From: Glynn Curtis [REDACTED]
Sent: 13 May 2021 14:47
To: Simon Davis <Simon.Davis@arun.gov.uk>
Cc: Neil Cairns [REDACTED]
Subject: RE: P/38/21/PL - Little Sefter Planning Application

Subject: RE: P/38/21/PL - Little Sefter Planning Application - Proposed Drainage Condition

From: MarkHobbs [REDACTED]
Sent: 07 May 2021 11:46
To: sarah.burrows@arun.gov.uk
Cc: 'Glynn Curtis' [REDACTED] Simon Davis <Simon.Davis@arun.gov.uk>
Subject: P/38/21/PL - Little Sefter Planning Application - Proposed Drainage Condition

PROJECT	BARN EXTENSION BARFOOTS - LITTLE SEFTER PAGHAM RD, BOGNOR REGIS WEST SUSSEX, PO20 1LN				
DRAWING	DRAFT PROPOSED EXTERNAL LEVELS & CONSTRUCTION FINISHES				
SCALE	PTN No	FC2846/03	REV	B	
Varies	DATE	JAN 20	INITIAL	MH	CHKD

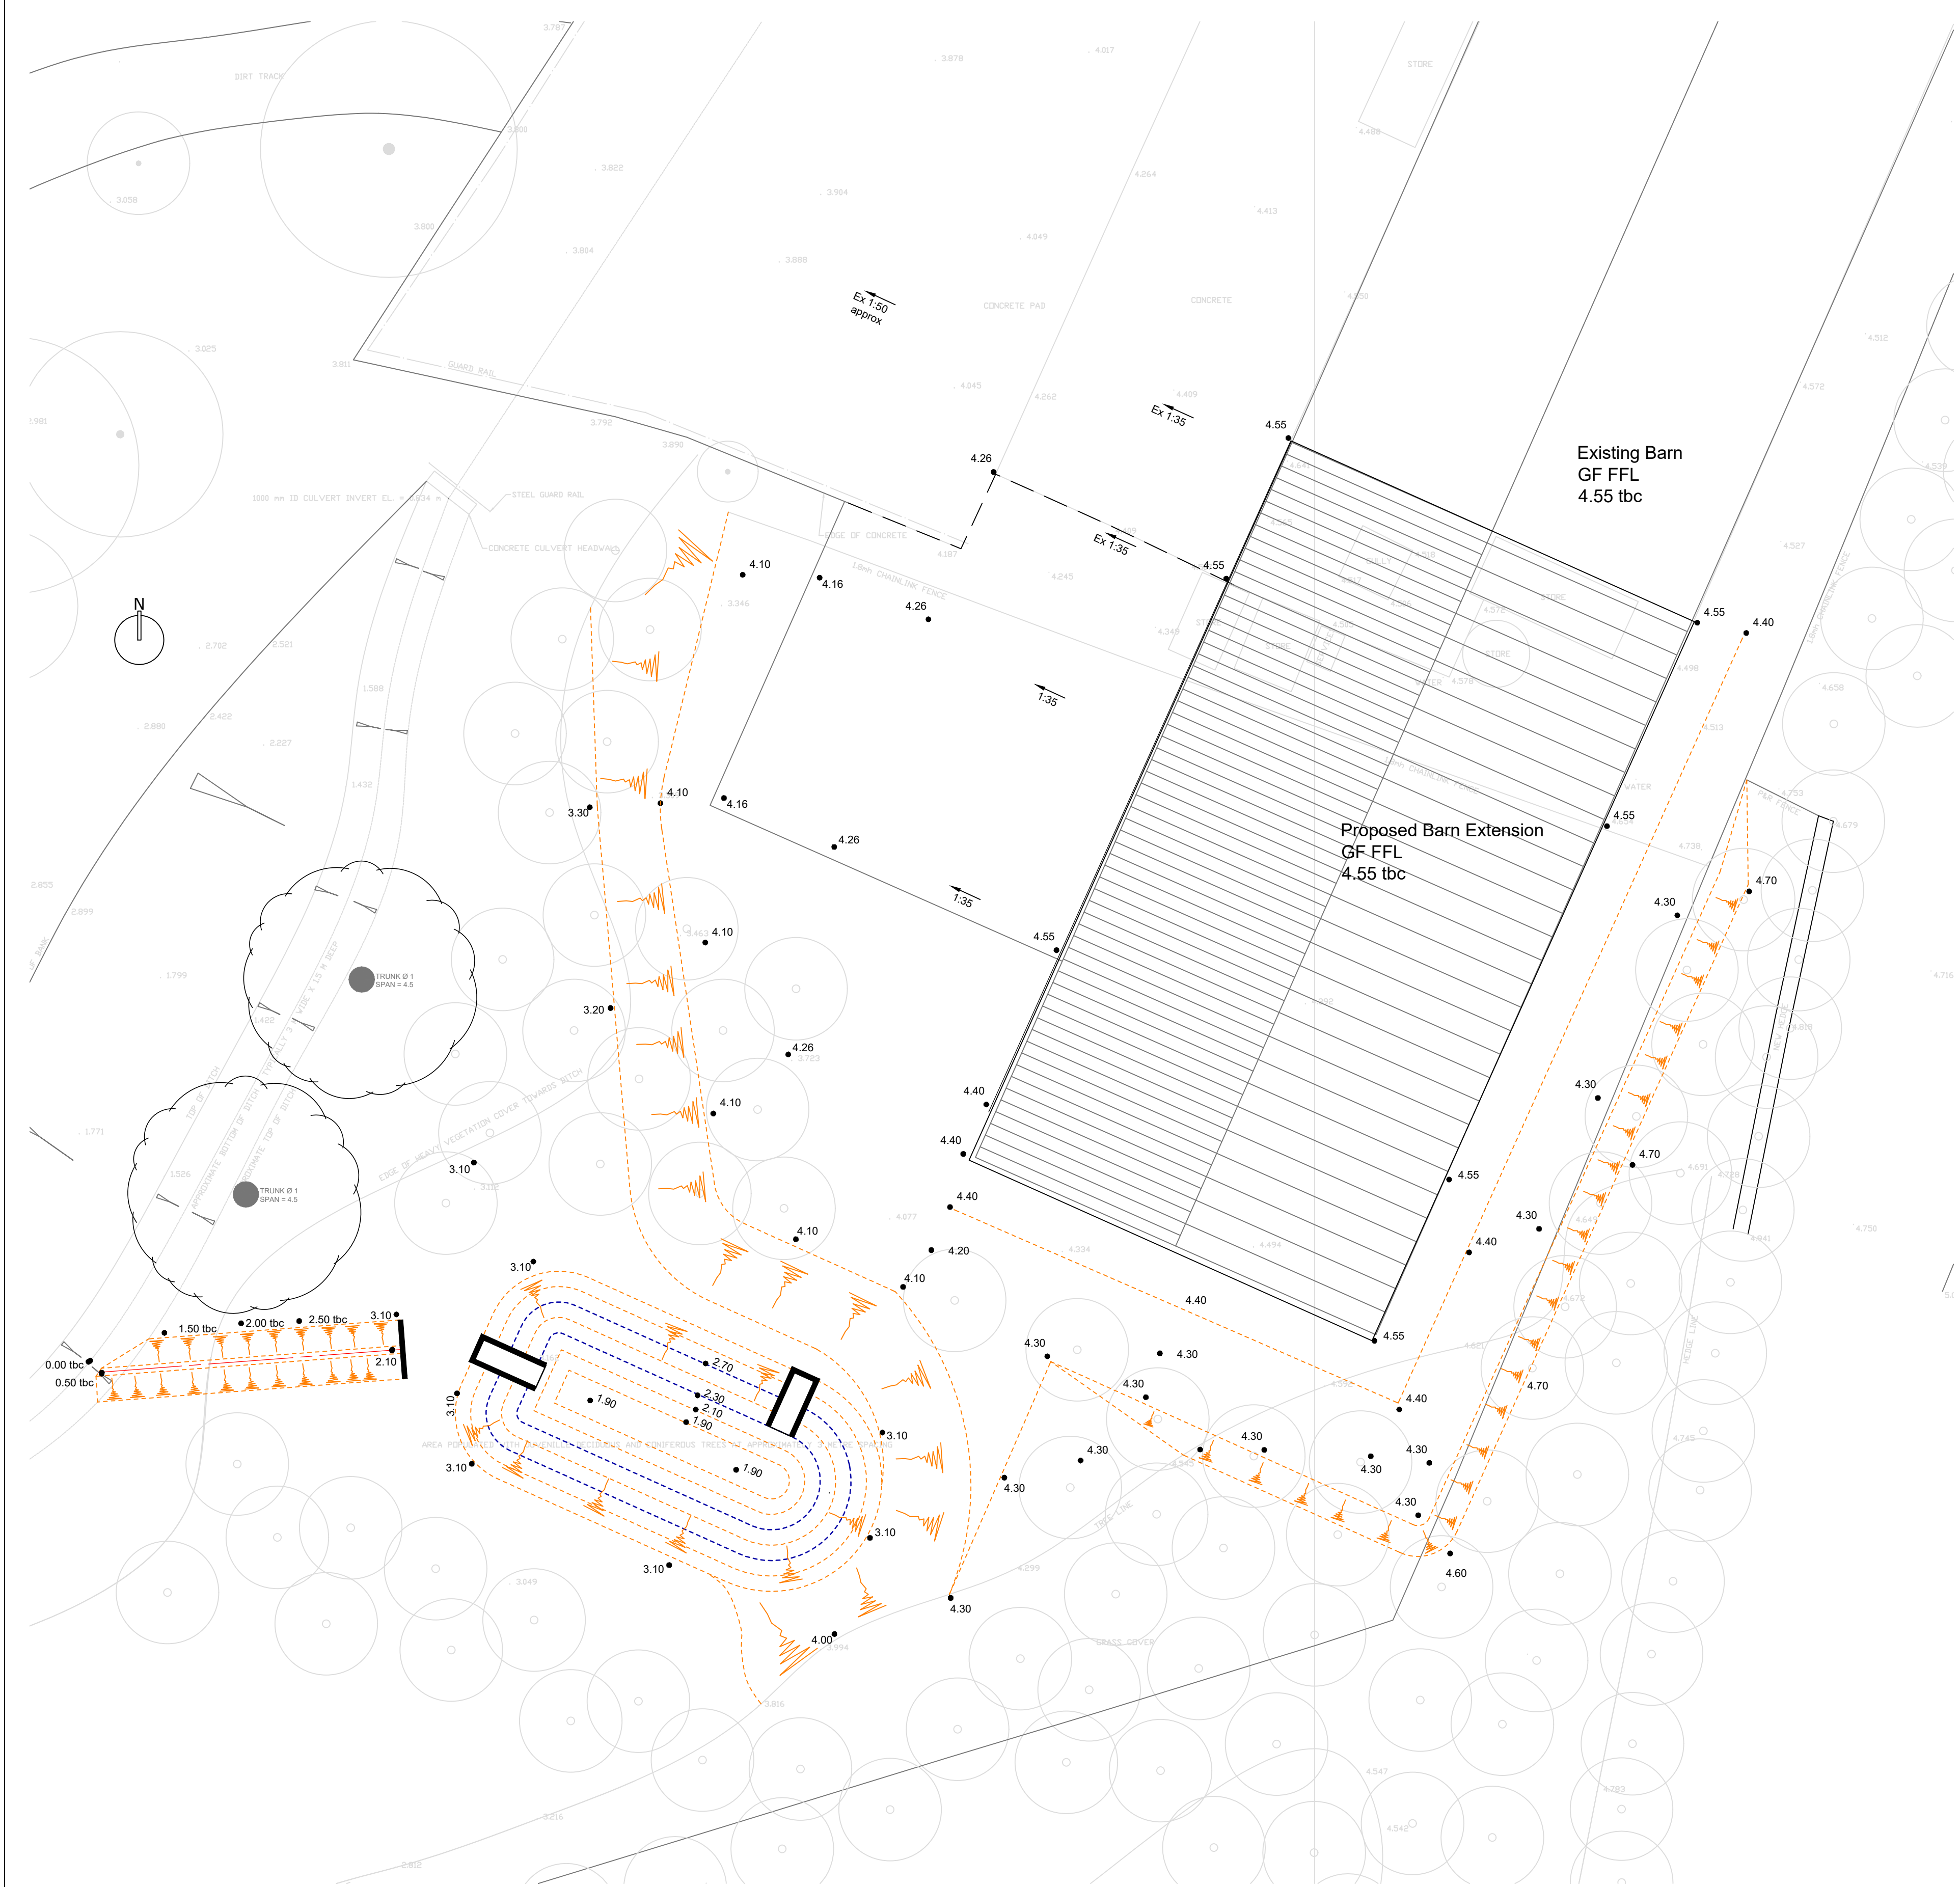
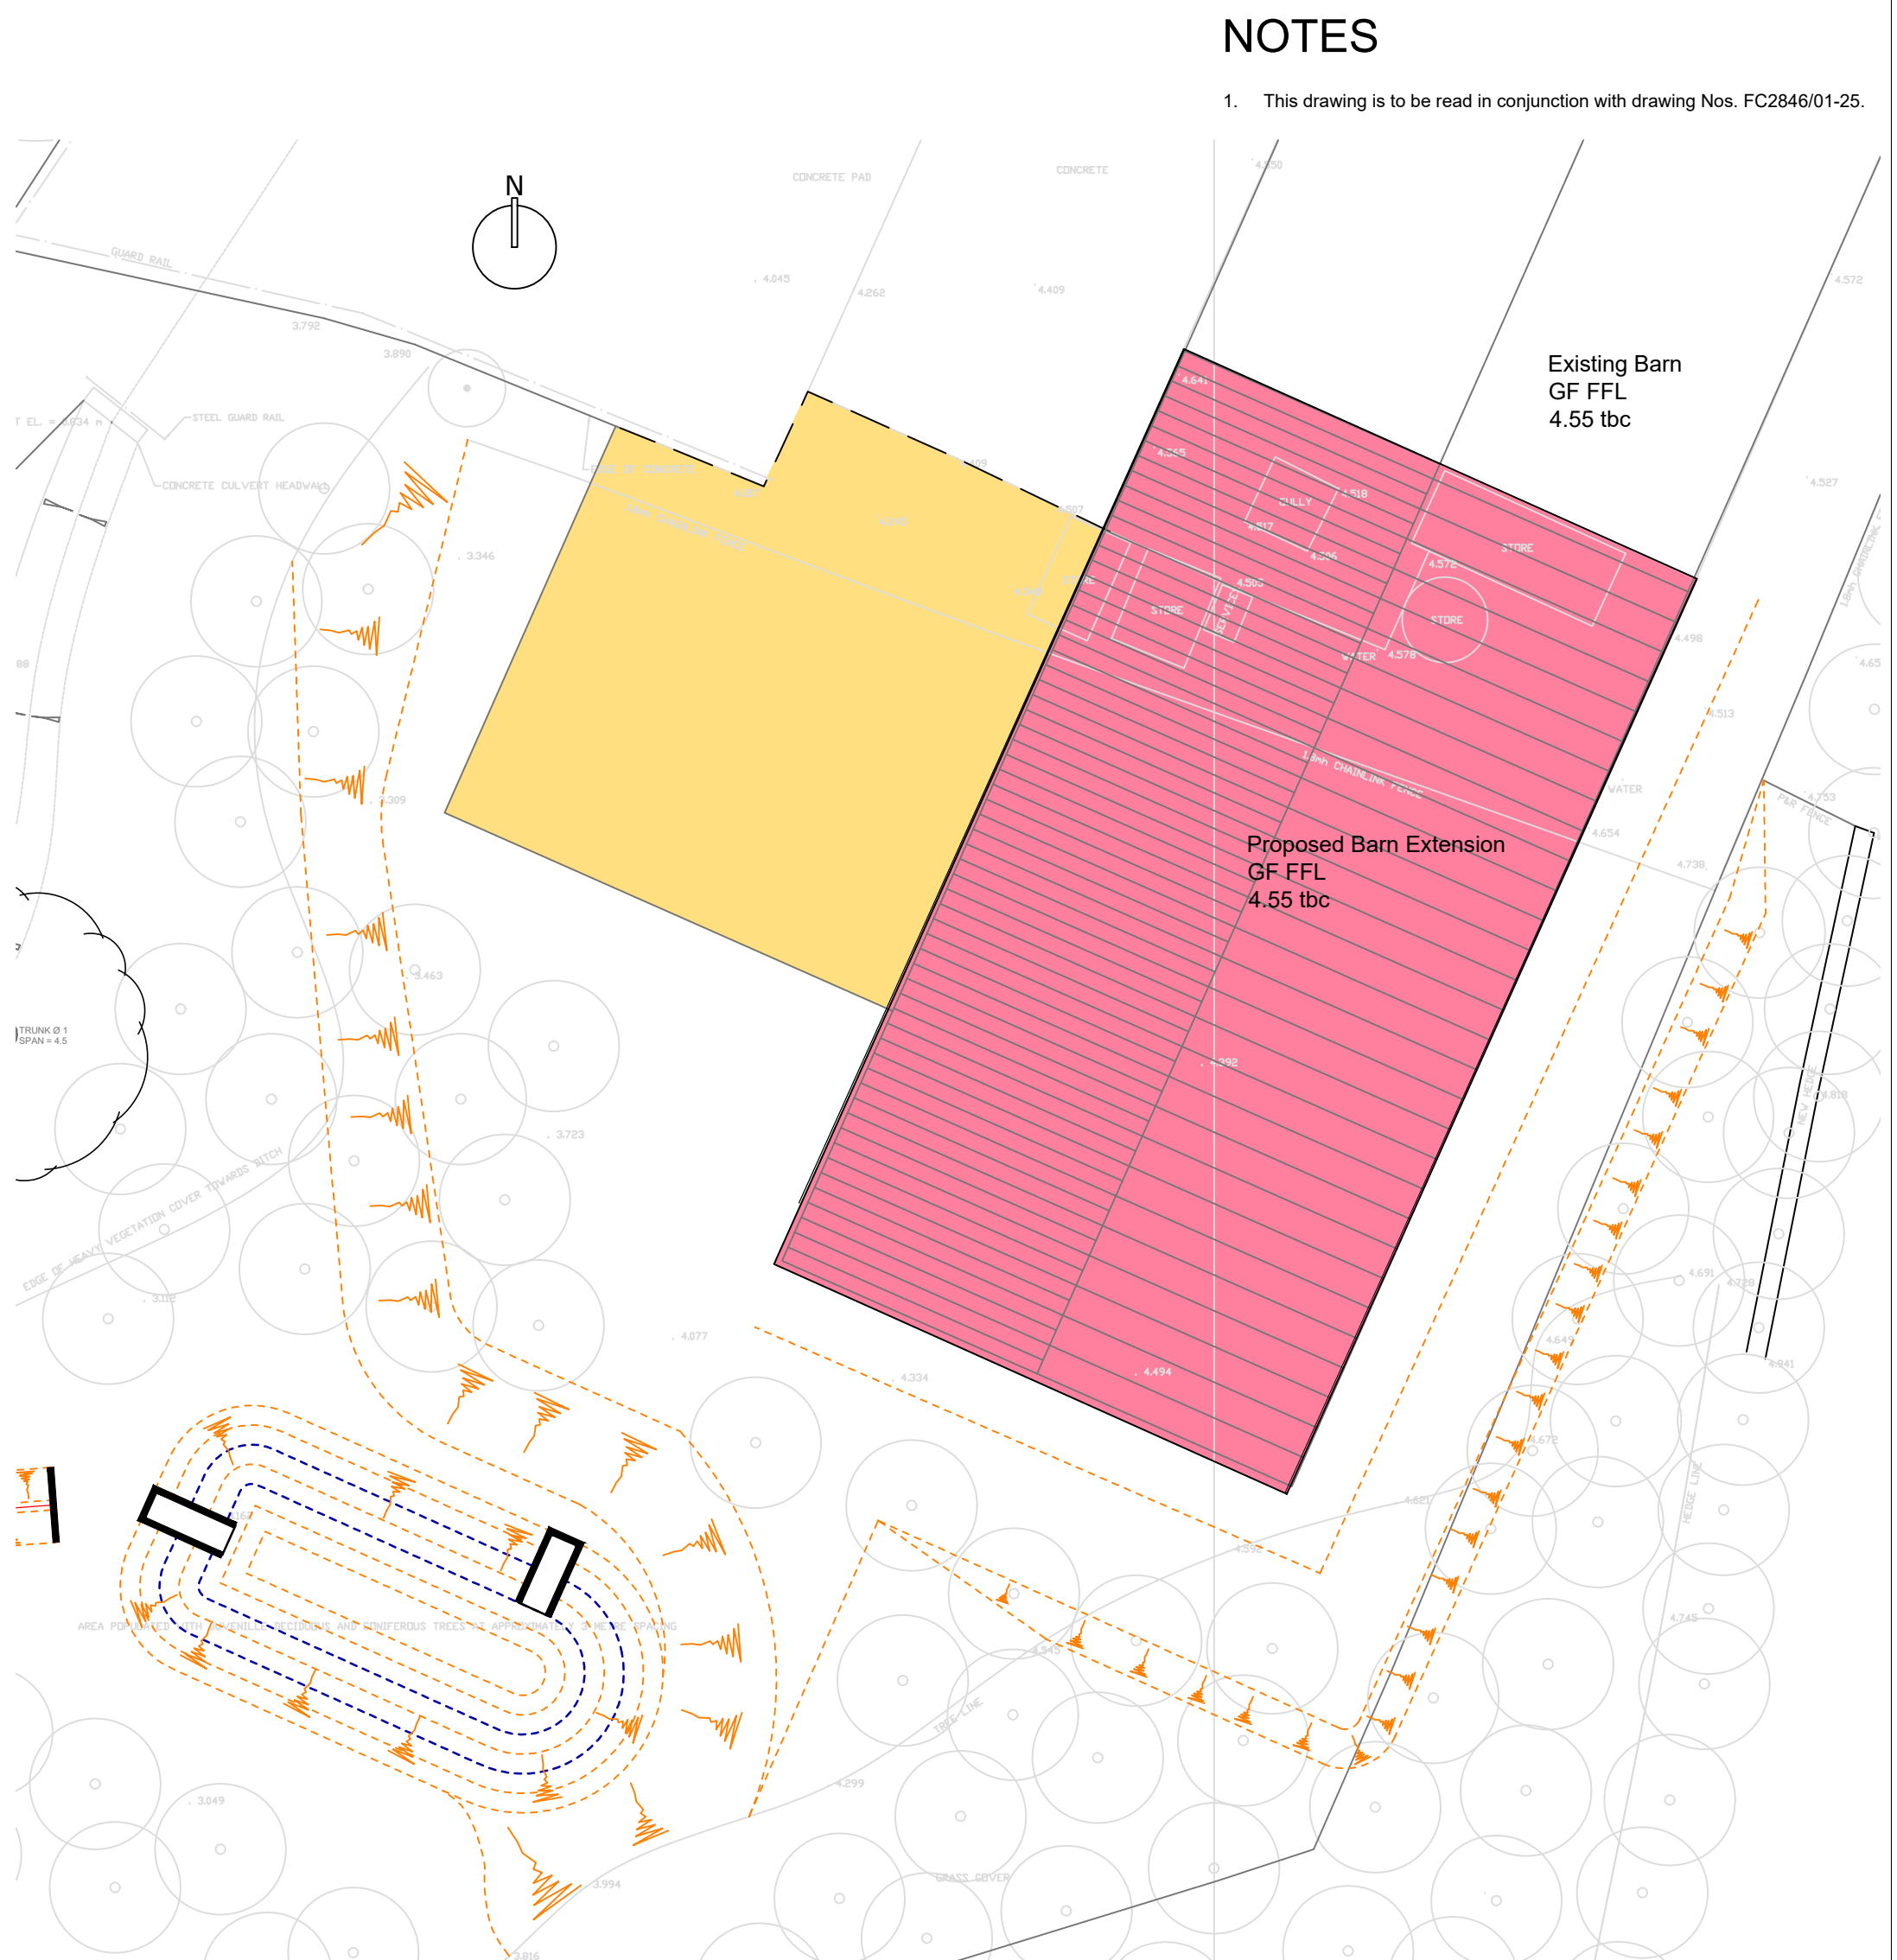
- Thus proposed Planning Condition PCENG2 should be amended to exclude '*Winter groundwater monitoring to establish highest annual ground water levels and winter Percolation testing to BRE 365, or similar approved, will be required to support the design of any Infiltration drainage*'

- The proposed restricted run off from the development has been set at 5l/s in line with DEFRA recommendations as the default minimum flow rate to avoid overburdensome/frequent blockages occurring.

- We appreciate that the site is small and that the greenfield site runoff rate would be lower than 5l/s , tending to 2l/s.
 - However, proposing a flow control restricting flows to 2l/s would in our opinion lead to a significant increase of blockage risk as the flow control will have a smaller orifice.

- Given that the system proposes a storage pond/swale with a wetted portion below the outlet level, and the feature is not tanked, then some infiltration and spare capacity will be present.

- However, our concern is the that the feature is a natural feature within a wooded glade, and thus twigs/leaves/vegetation will be regular sources of debris that could cause a blockage of the flow control. Obviously we can provide screening to the outlet headwall from the pond/swale, though that will only move the blockage upstream.

- We would suggest that a 5l/s flow control would have an adequate orifice to cater for the majority of blockage issues without overburdensome maintenance regime.

- It is suggested that a 2l/s flow control would only be prudent within a sealed/closed system such as outlet from sealed tanks/porous paving systems where the risk of blockage through debris is extremely unlikely.

- We trust that after reconsidering the system proposed and the wider natural benefits that it offers that you can agree to the proposed 5l/s restricted discharge rate in this instance.

Our Engineers have now recommended an amendment to the condition to remove the winter monitoring requirement as this has been done.

Development shall not commence, other than works of site survey and investigation, until full details of the proposed surface water drainage scheme have been submitted to and approved in writing by the Local Planning Authority. The design should follow the hierarchy of preference for different types of surface water drainage disposal systems as set out in Approved Document H of the Building Regulations, and the recommendations of the SuDS Manual produced by CIRIA. No building / No part of the extended building shall be occupied until the complete surface water drainage system serving the property has been implemented in accordance with the agreed details and the details so agreed shall be maintained in good working order in perpetuity."
